Developer Services
Southern Water
Sparrowgrove House
Sparrowgrove
Otterbourne
Hampshire
SO21 2SW

Your Ref
F/19/18/EIS
Our Ref
PLAN-025784
Date
05/12/2018

Proposal: Scoping opinion for development of up to 1,500 dwellings, up to 37,000 sqm of employment floor space, a local centre including retail, commercial and community facilities, primary school, nursery, a care/retirement home, healthcare facilities, public open space, new sports pitches and facilities, & associated access, infrastructure, landscape & ancillary works
Site: Ford Airfield, Ford, BN18 0HY.
F/19/18/EIS

SOUTHERN WATER

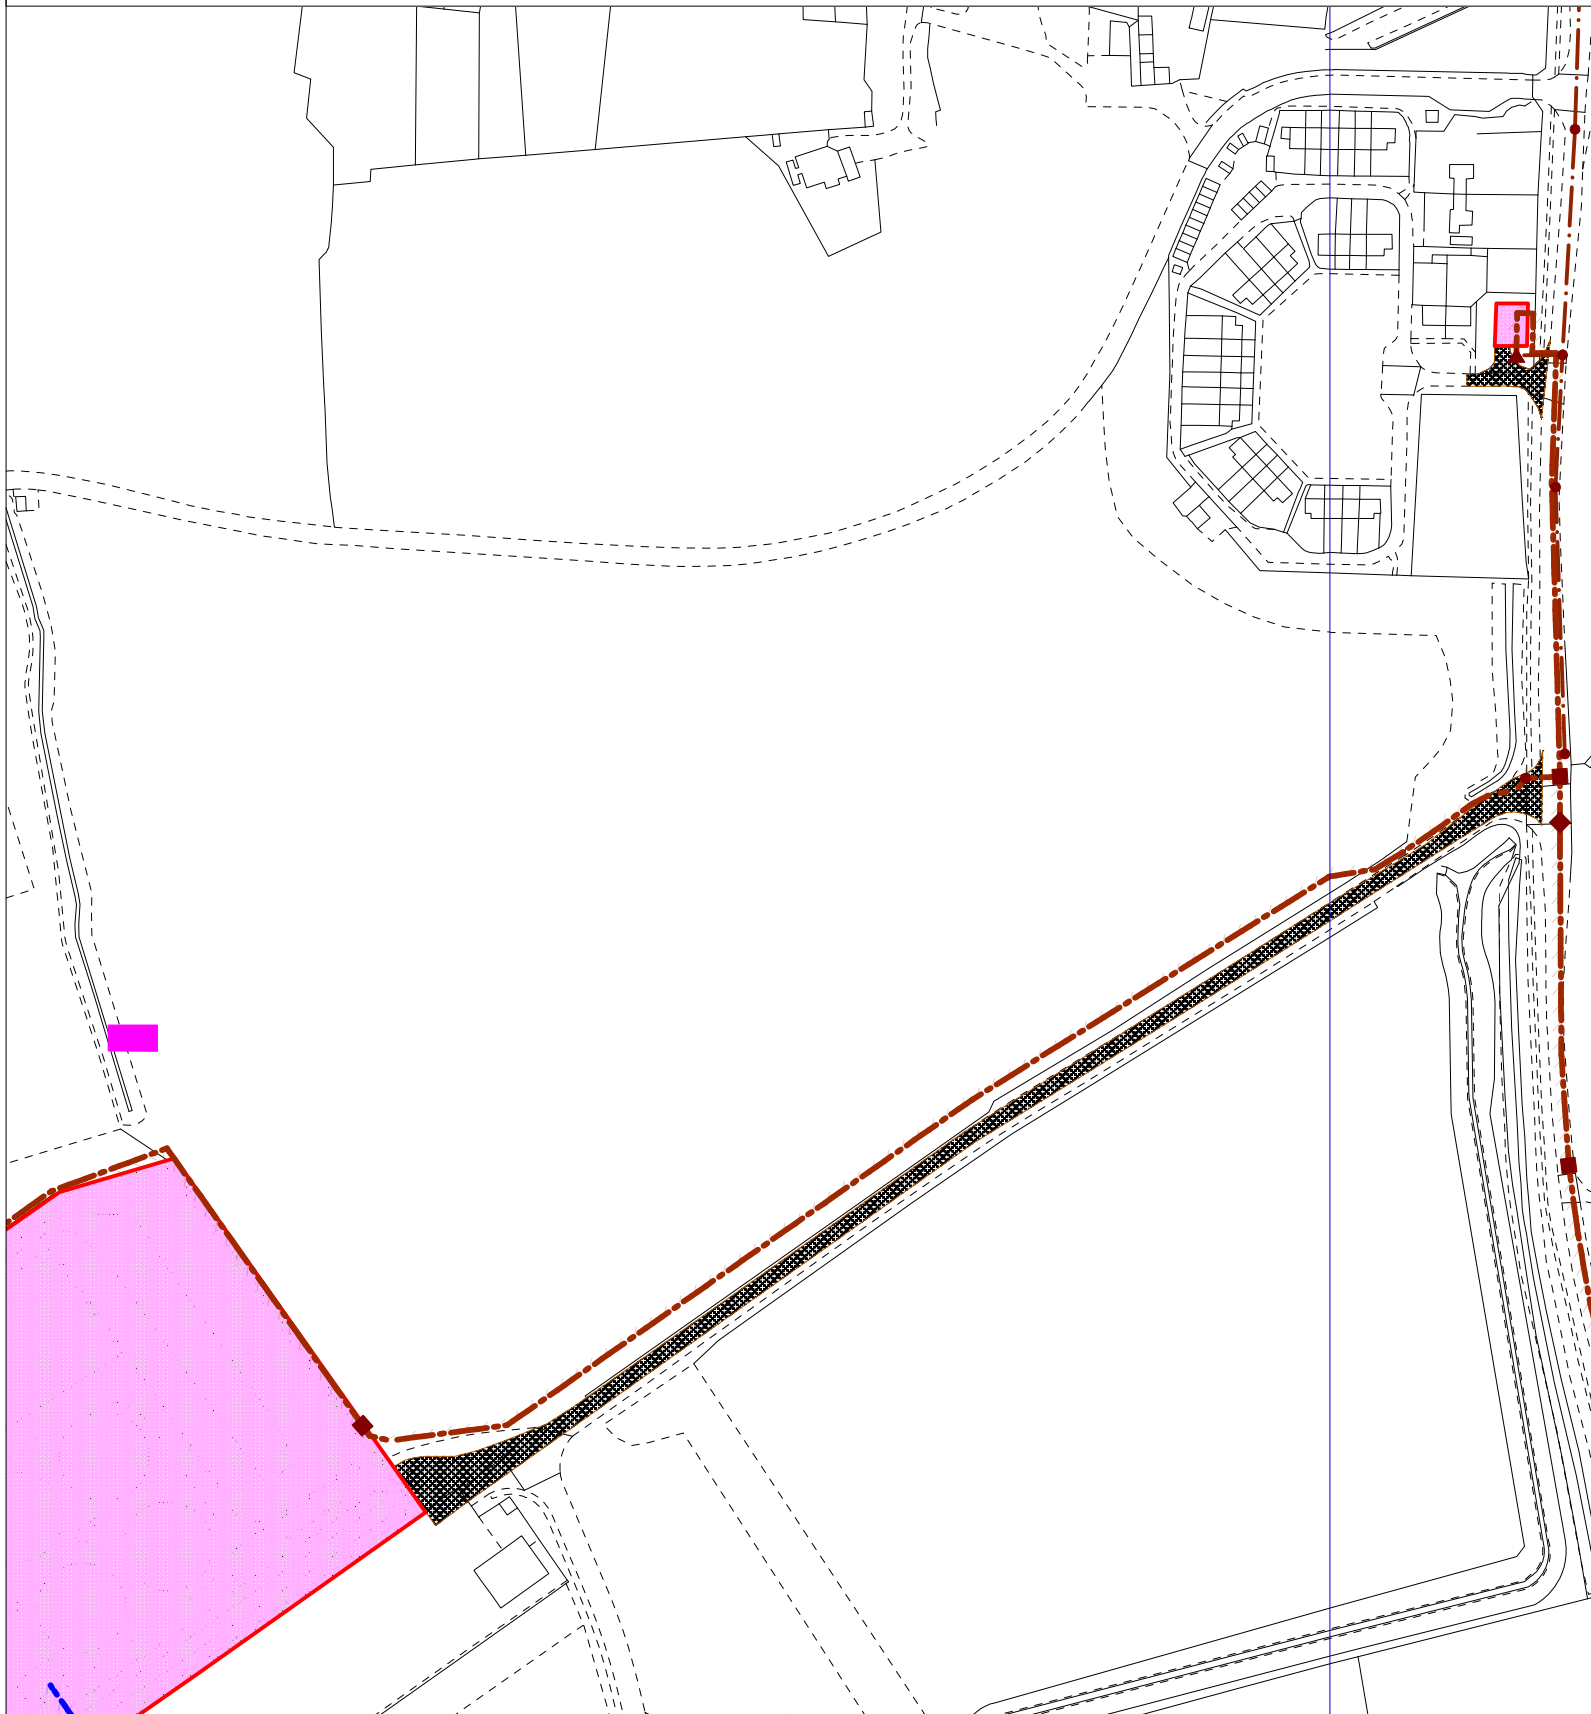
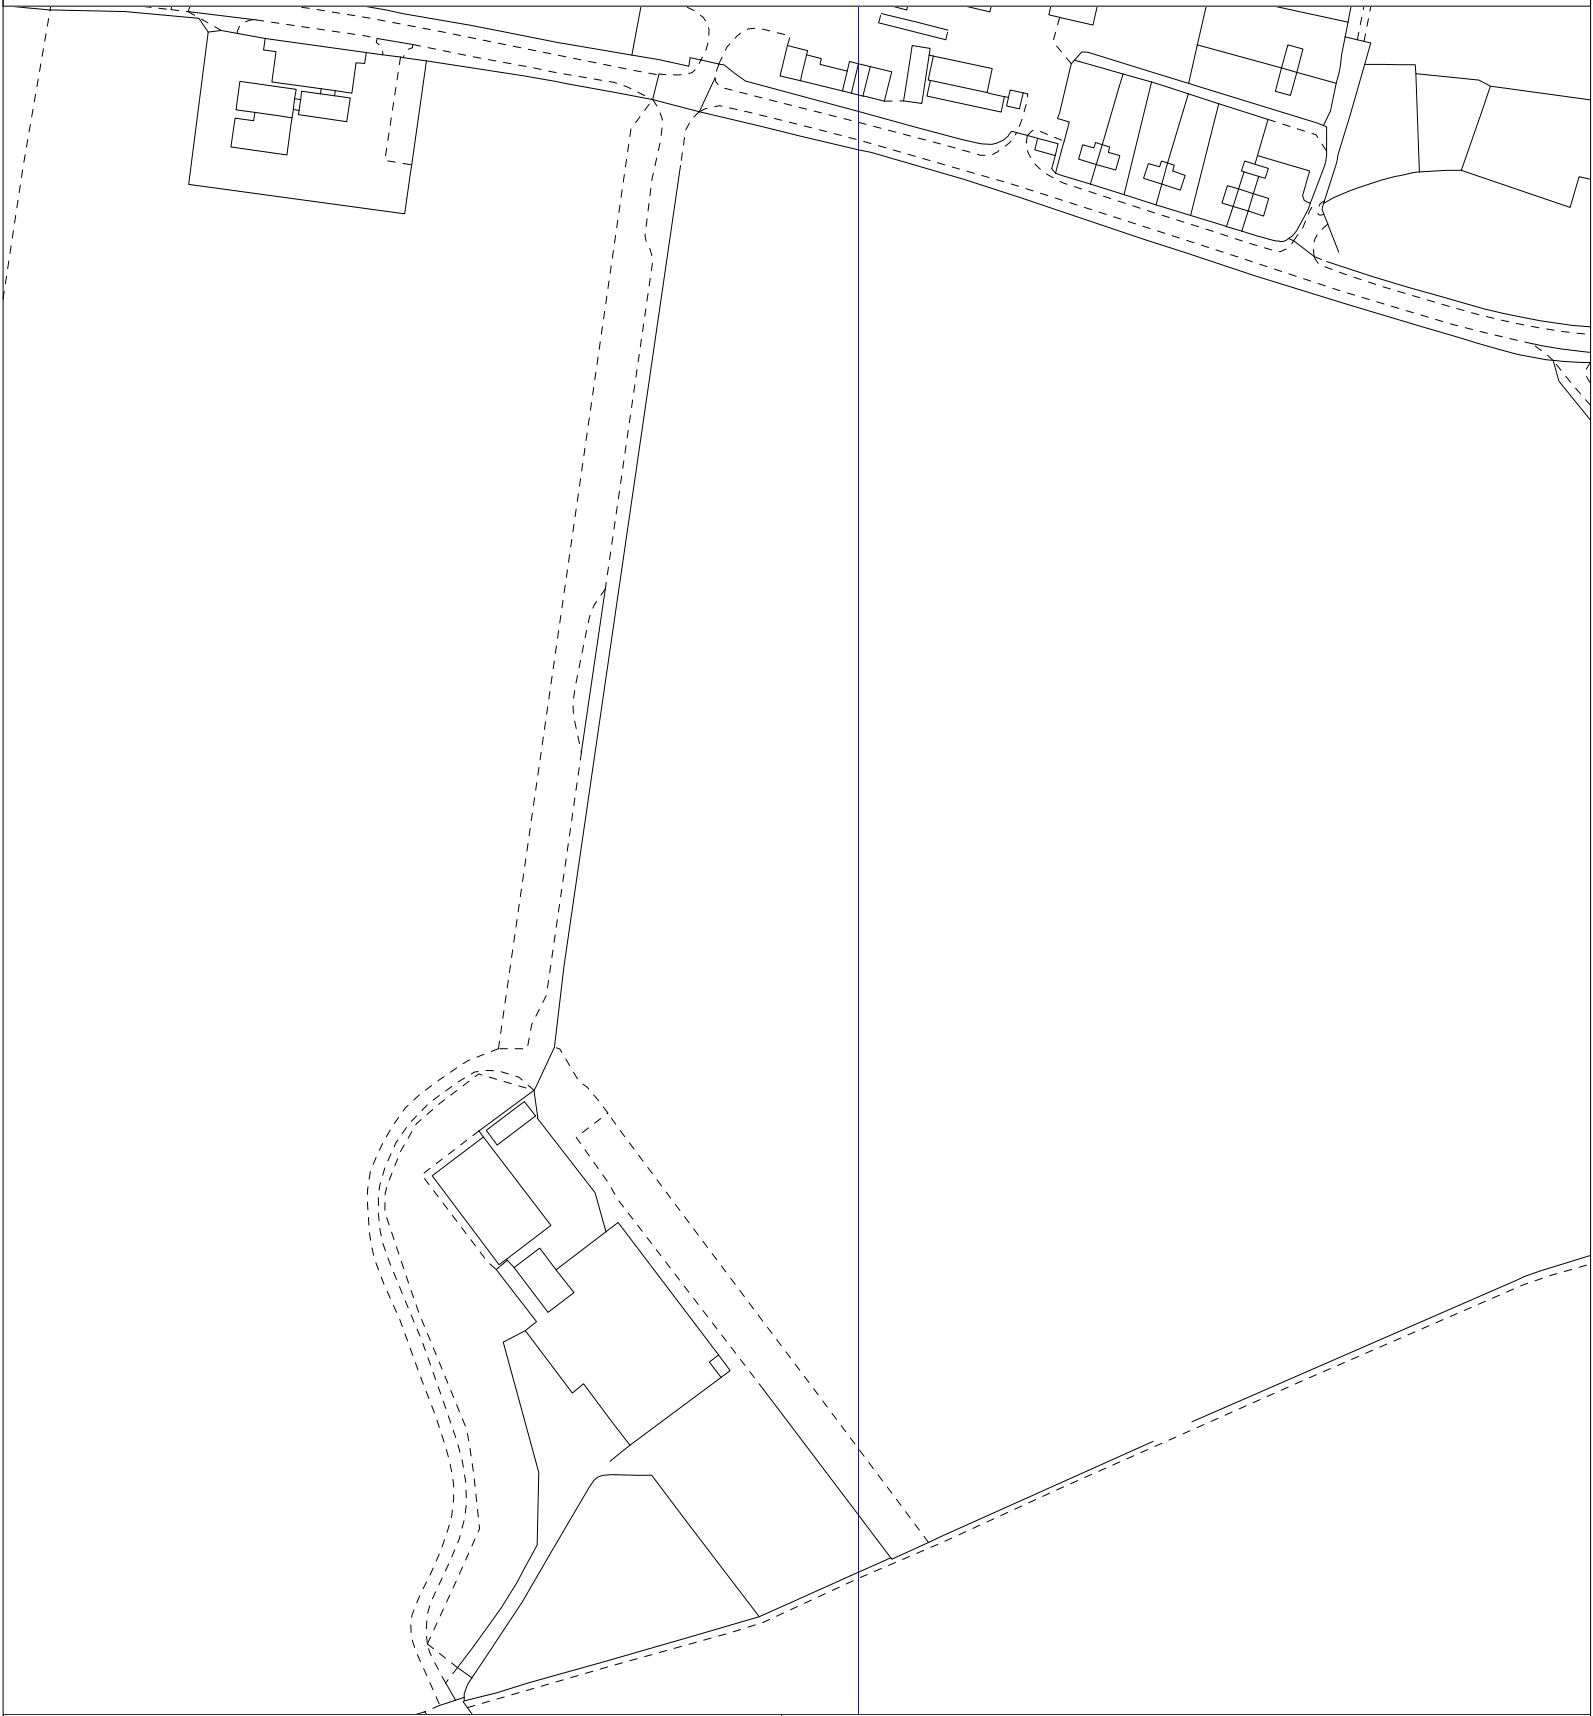
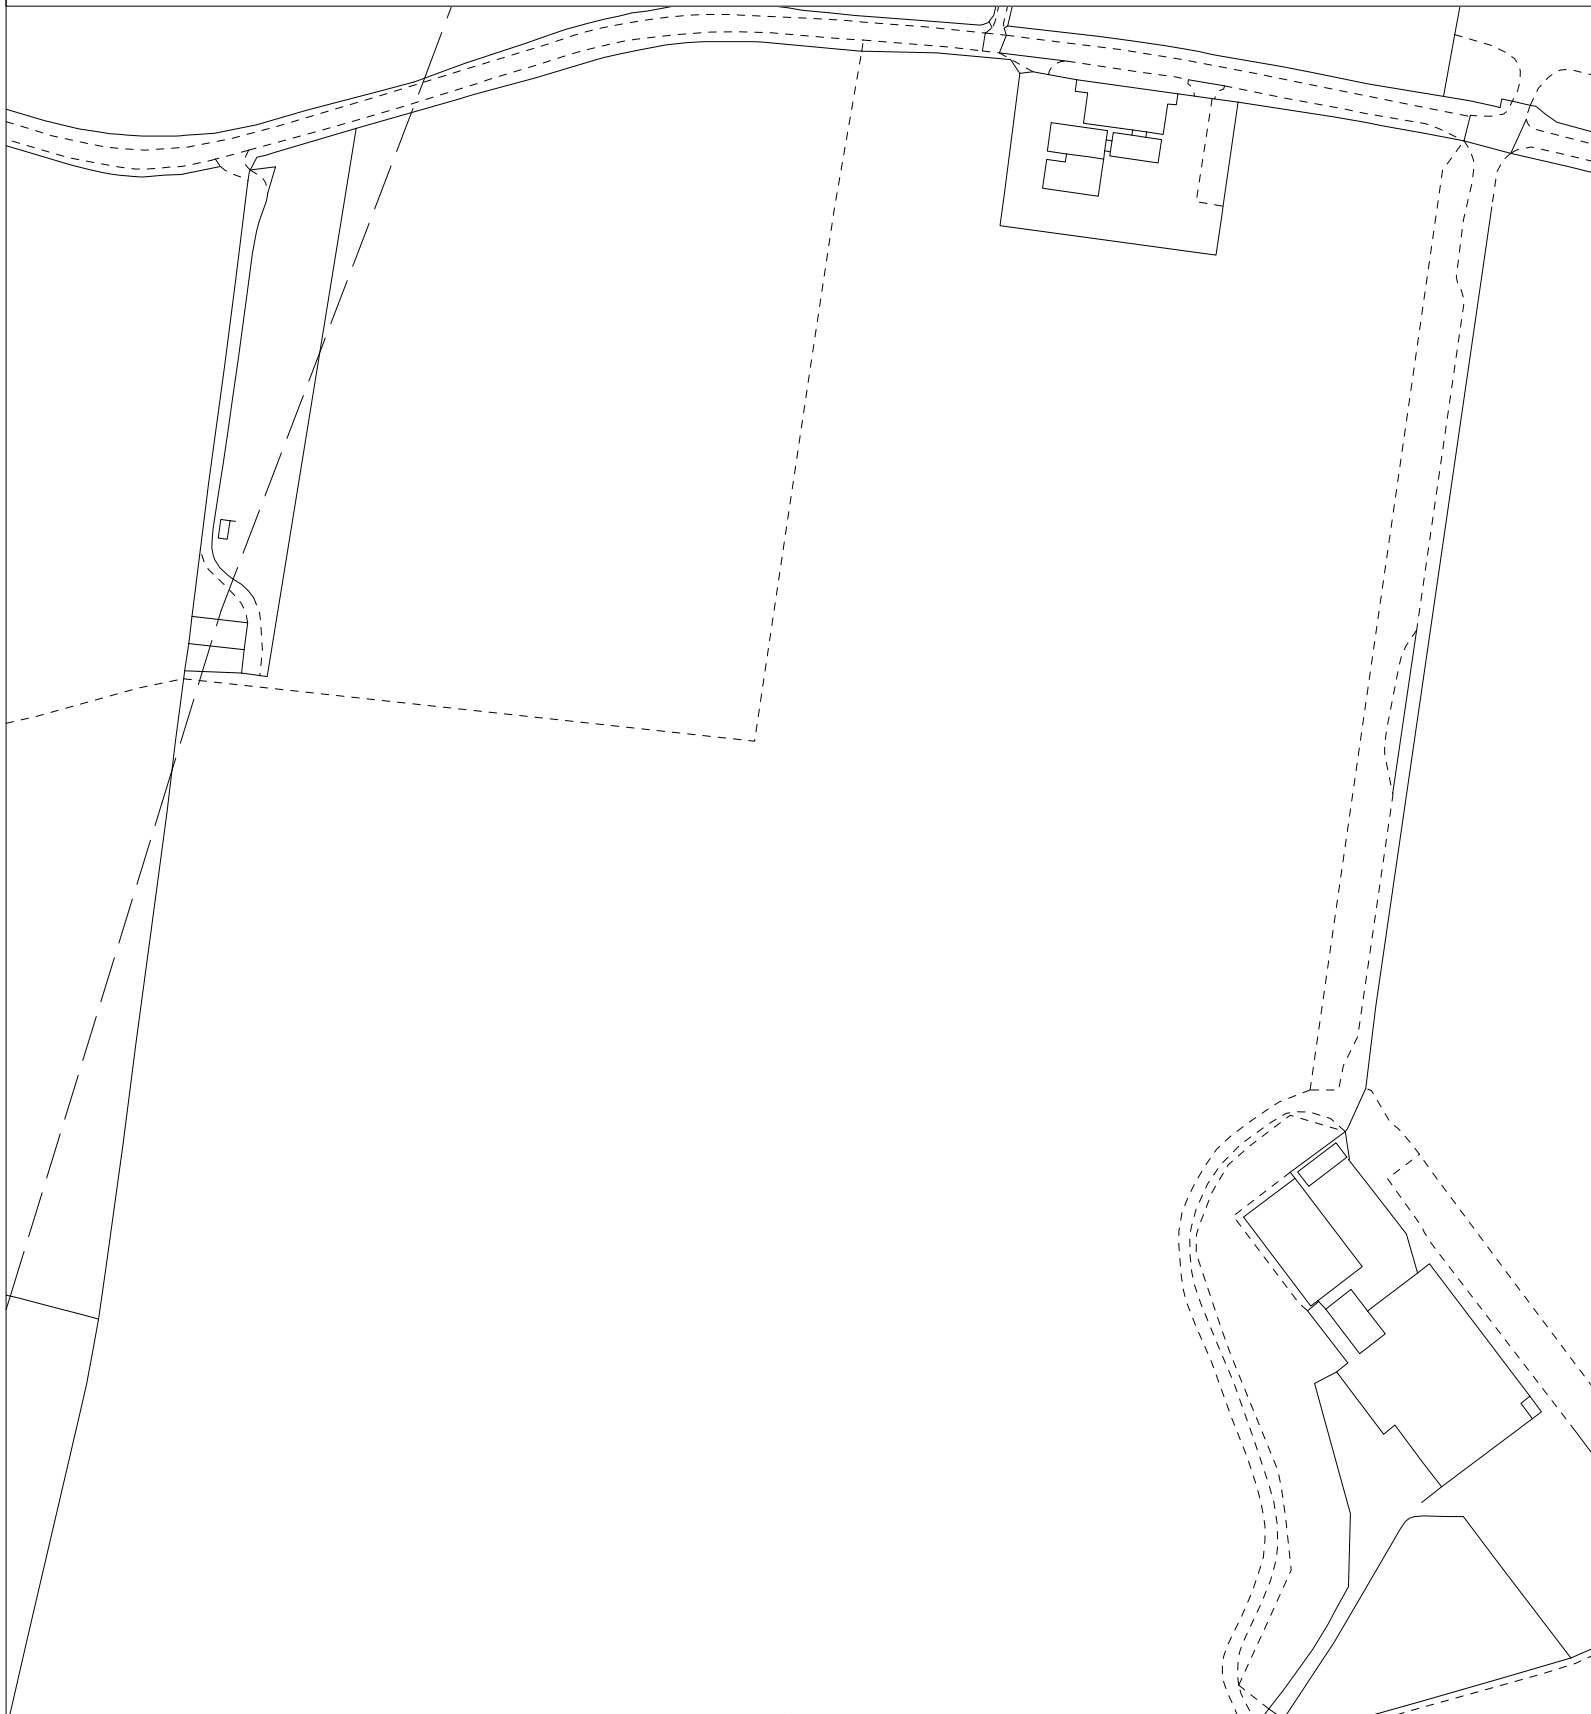
- Southern Water's current sewerage/water records show that there are foul rising mains (100mm, 125mm, 180mm, 500mm & 600mm) and 700mm (treated effluent) rising main within the proposed development site.
 - No new development/building works will be permitted to be constructed over or within 3.0 metres of the existing 100mm, 125mm, 180mm foul rising mains. Sewer record attached for your information.
 - No new development/building works will be permitted to be constructed over or within 3.5 metres of the existing 500mm and 600mm foul rising mains. Sewer record attached for your information.
 - No new development/building works will be permitted to be constructed over or 4.0 metres of the existing 700mm (treated effluent) rising main. Sewer record attached for your information.

- No new soakaways should be located within 5 metres of a public sewers and rising mains.
- In addition, due to changes in legislation that came in to force on 1st October 2011 regarding the future ownership of sewers it is possible that a sewer/s now deemed to be public could be crossing the above property.
